*Application for an Order granting Development Consent
for Botley West Solar Farm –(EN-010147)*

Botley West Solar Farm EN010147
Response by Stop Botley West (SBW)

Response to submissions of 16 July

Figure 5 - Illustrative Masterplan

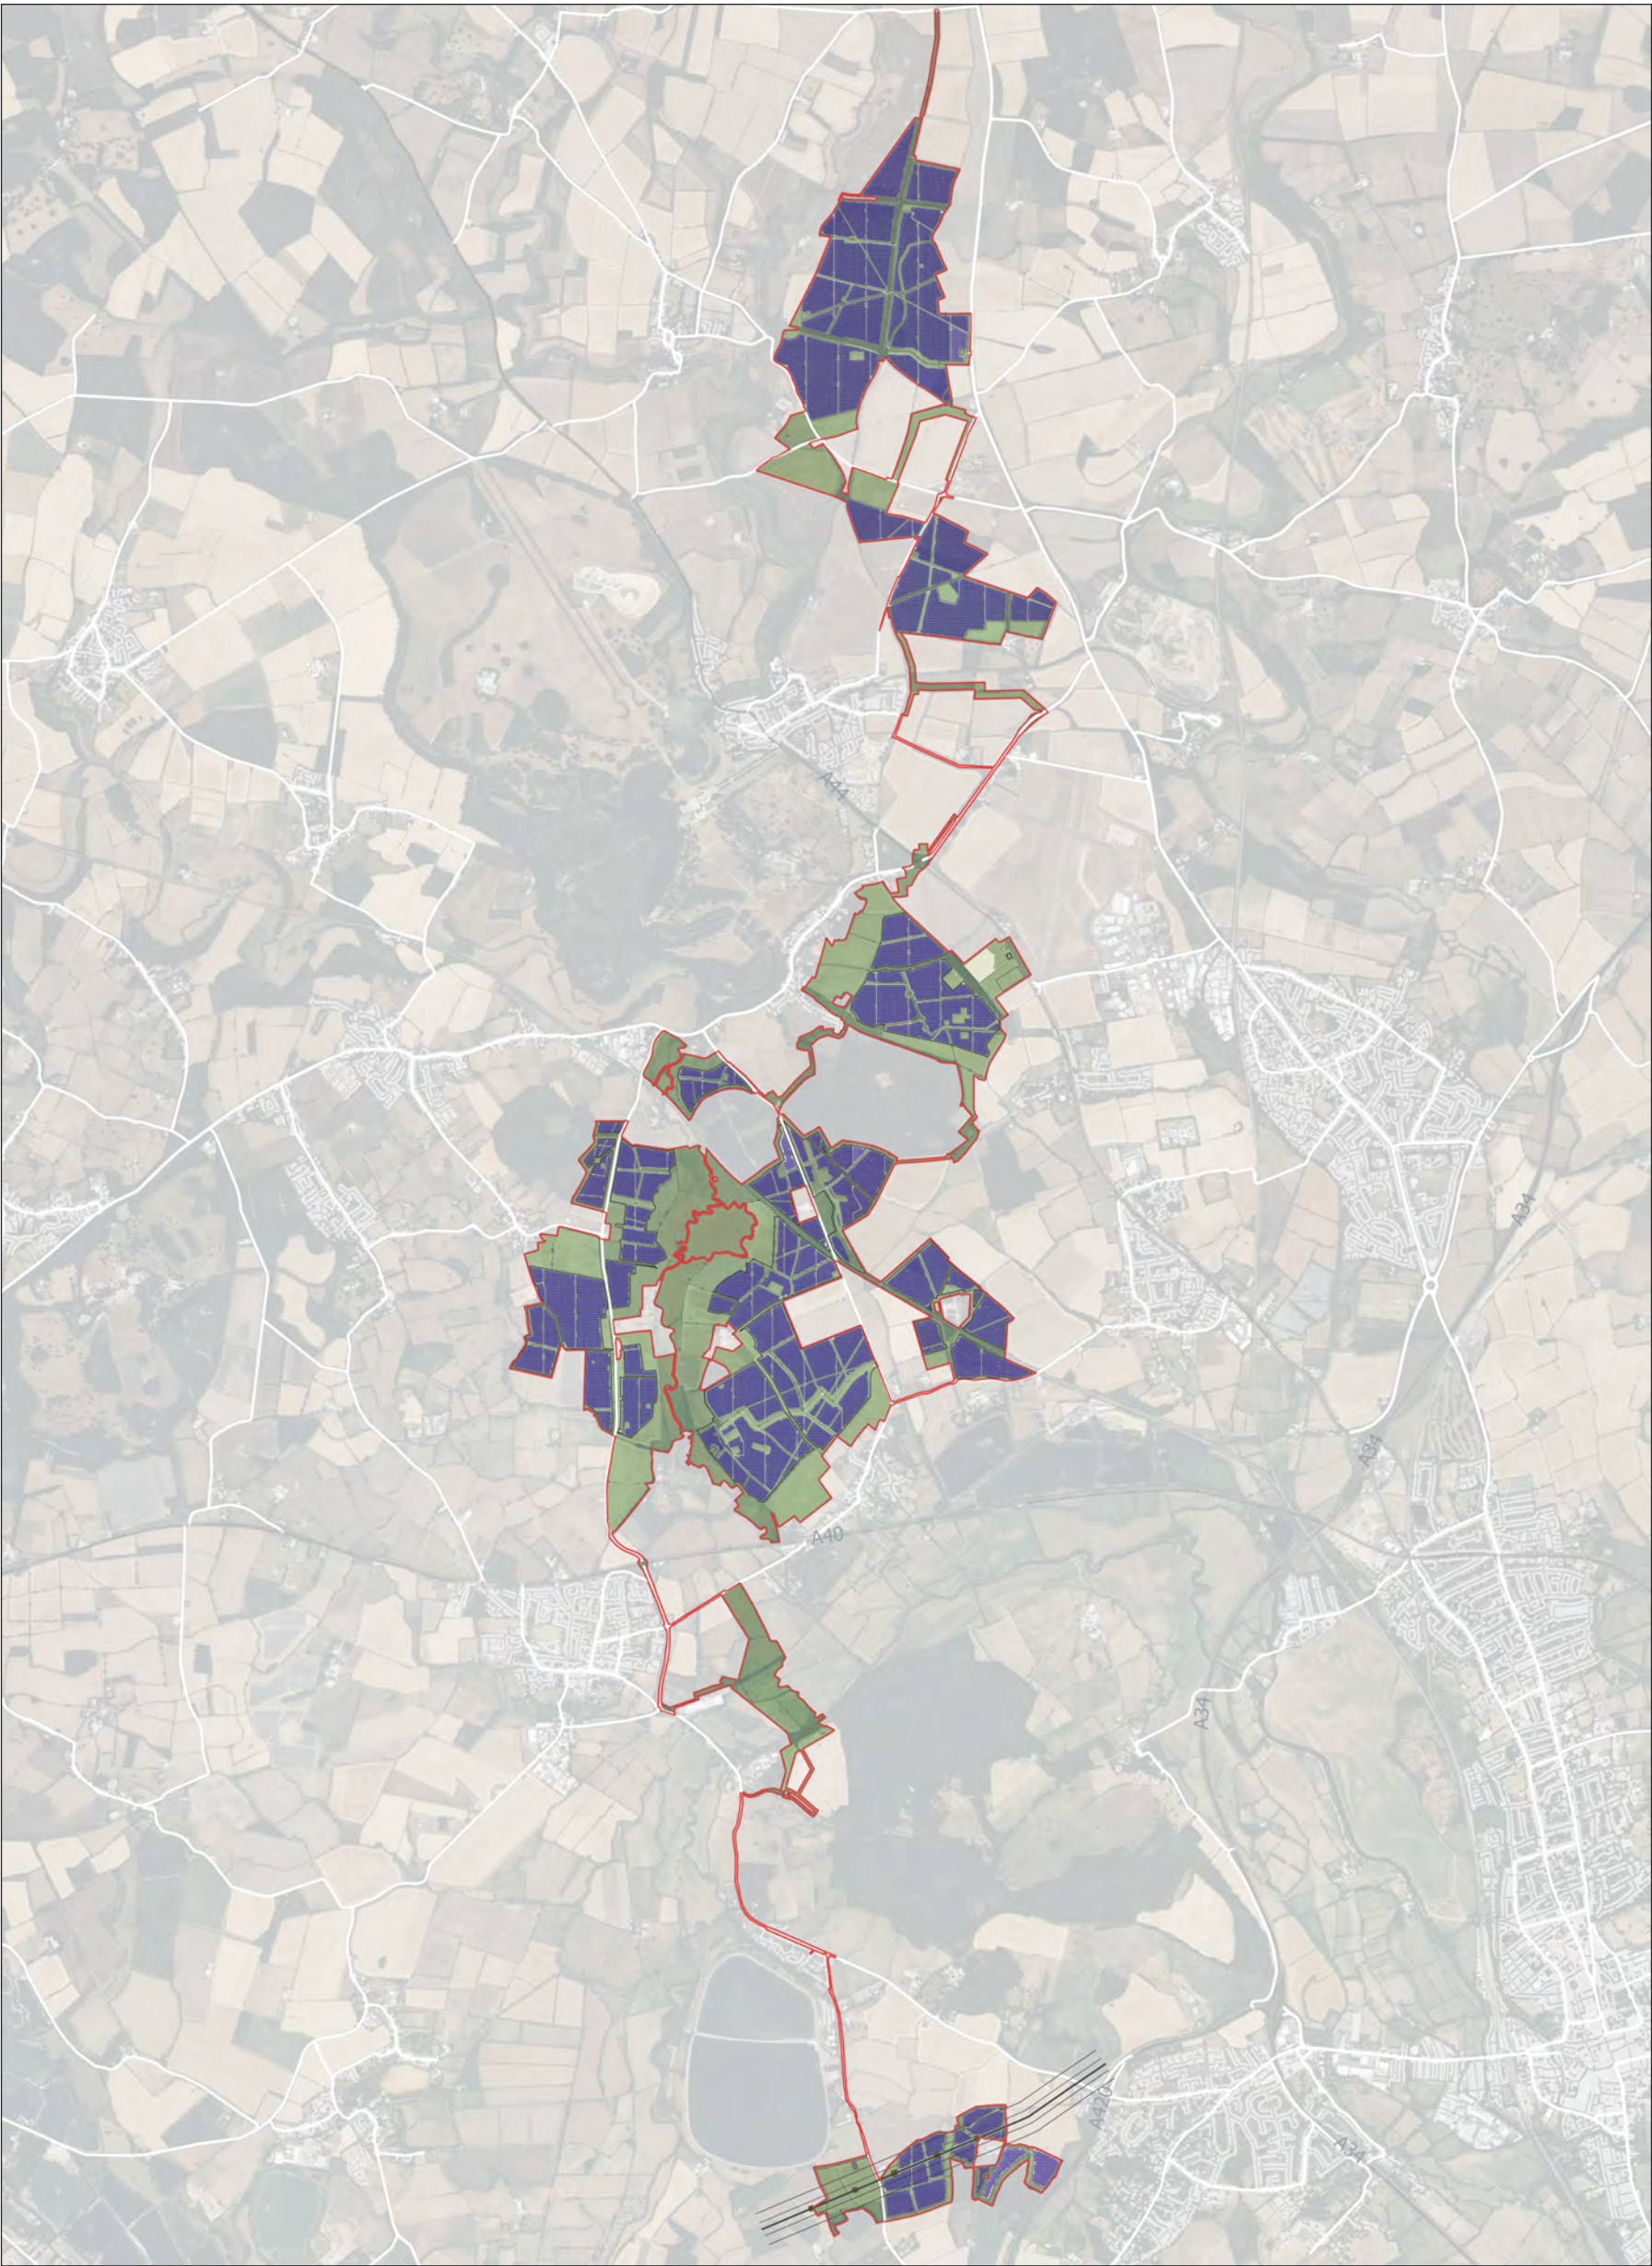
In the Applicant's latest (16 July) submission [C1-108, C1-109], its newly appointed consultants, Icen, have devised an "outline Residential Visual Amenity Plan" (oRVAP) Ref [C1-108] offering 100m as standard "with additional offsets up to 250m applied where needed". No criteria have been provided to explain how this "need" would be assessed post consent when it will be beyond public scrutiny.

Through this mechanism the Applicant has effectively changed the likely buffer for most properties to the minimum 100m instead of the buffer of 250m recommended by ExA and shown in the 9 June submission. By describing this change as an "improvement" comparing the new Masterplan (rev 5) with Masterplan rev3 of 11 Nov 2023 rather than with Masterplan rev4 of 9 June 2026, the Applicant has disguised the fact that the latest proposal is actually a regression.

June 9	July 16
Masterplan revision 4 [C1-051]	Masterplan revision 5 [C1-118]
Buffer of 250m shown	Buffer of 100m shown
New requirement 15 in Schedule 2 of dDCO describes a post consent RVAP (newly proposed on 9 June and not formally examined by ExA) which must set out justification for the distance proposed between 100m and 250m and must be approved by the local planning authority.	Amended requirement 15 in Schedule 2 of dDCO says: <i>"The RVAP must be substantially in accordance with the outline RVAP"</i> . Note: this oRVAP [newly proposed on 16 July] has not been formally examined by ExA nor approved by the local planning authority.
In response to the SoS request for information (letter 20/4/2026), the Applicant offered to increase the buffer distances from sensitive receptors [to 250m], as illustrated in the updated Masterplan Rev 4, stating: <i>"It is judged that these updates would result in beneficial effects for a number of individual residential receptors and settlement areas including, but not limited to, the residential visual amenity of Dornford Cottage, properties at Shipton Slade Farm, properties in Bladon, Burleigh House, College Farm and Church Hanborough"</i> .	Masterplan Rev 5. [C1-020] is informed by the new RVAA which repeats the previous errors in assessing whether vegetation already screens the property and consequently underestimates the impact on residential visual amenity for properties such as Dornford Cottage, Shipton Slade, College Farm, Goose Eye Farm and others. The effect of reducing the buffer to 100m would be to reverse the "beneficial effects" described on 9 June.

There is no justification for the most recent reduction of buffer size from 250m to 100m for most properties. Indeed, in its answer [C1-087] to question 27 of SoS 14 April letter, the Applicant admitted that that the project would still be viable, albeit marginally, with 250m buffers for all.

Masterplan revision 5 [C1-118] submitted on 16 July conversely shows buffers of **100m**.
